From: Liz Annalls [REDACTED]
Sent: 27 January 2022 12:10
To: Planning.Responses <Planning.Responses@arun.gov.uk>
Subject: RE: Planning Consultation on: Y/7/22/PL

Application No: Y/7/22/PL
Site Address: Land adjacent to Bonhams & Flints Hoe Lane Flansham PO22 8NP
Description of Works: Erection of 4 No dwelling with access from Hoe Lane and associated landscaping, including native orchards and wildflower meadows. This application is a Departure from the Development Plan and is in CIL zone 3 and is CIL Liable as new dwellings.

Liz Annalls
Environment Officer
Environmental Protection
Chichester District Council

Figure 3. Ponds within 500m of the site (MagicMap, 2021).

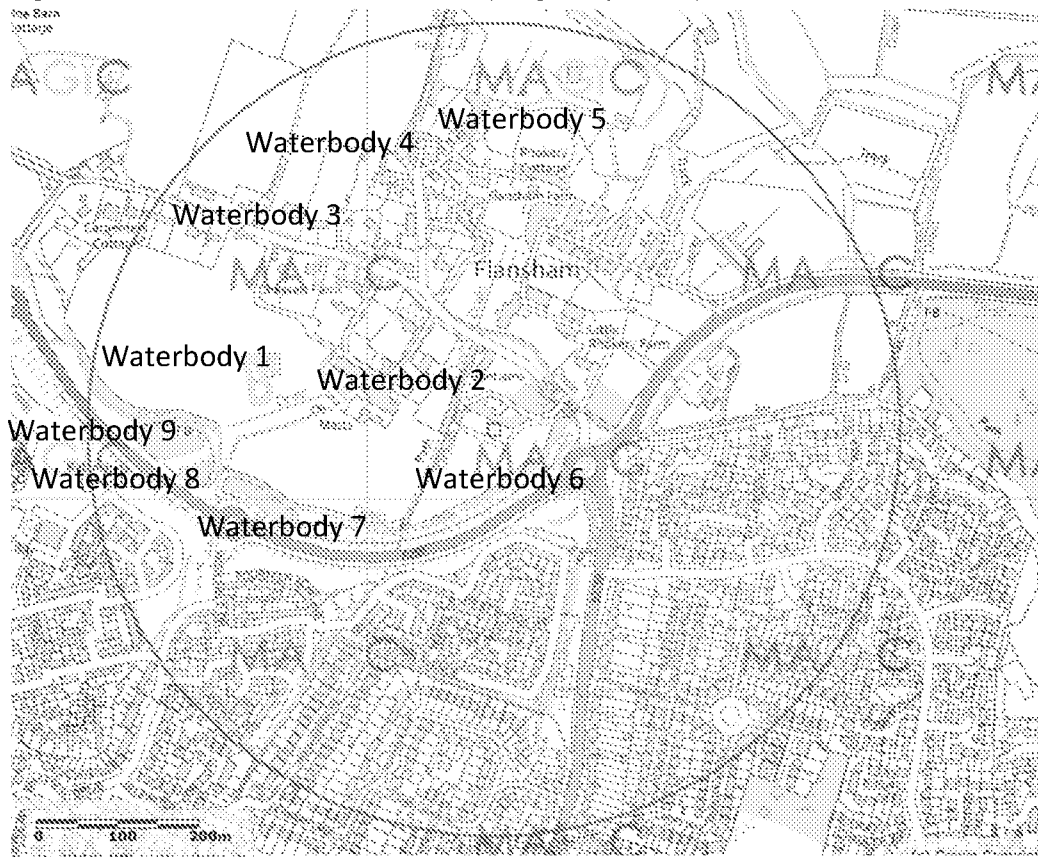
As detailed within the Ecological Survey (Nov 2021) further Great Crested Newt surveys are required in water body 6 and 7 in the form of eDNA assessments. If Great Crested Newts are found to be present further survey work would be required. We require that these surveys are undertaken prior to determination and submitted as part of this application.

As detailed within the Ecological Survey (Nov 2021) there is potential for Great Crested Newts to be using the terrestrial habitat onsite. Due to this and as recommended within the survey a further eDNA sampling survey is required on both ponds. The results of these surveys can then be used to create a suitable mitigation strategy and inform a Natural England protected species license if required. We require that these surveys are undertaken and the report and the mitigation strategy submitted with the planning application prior to determination.
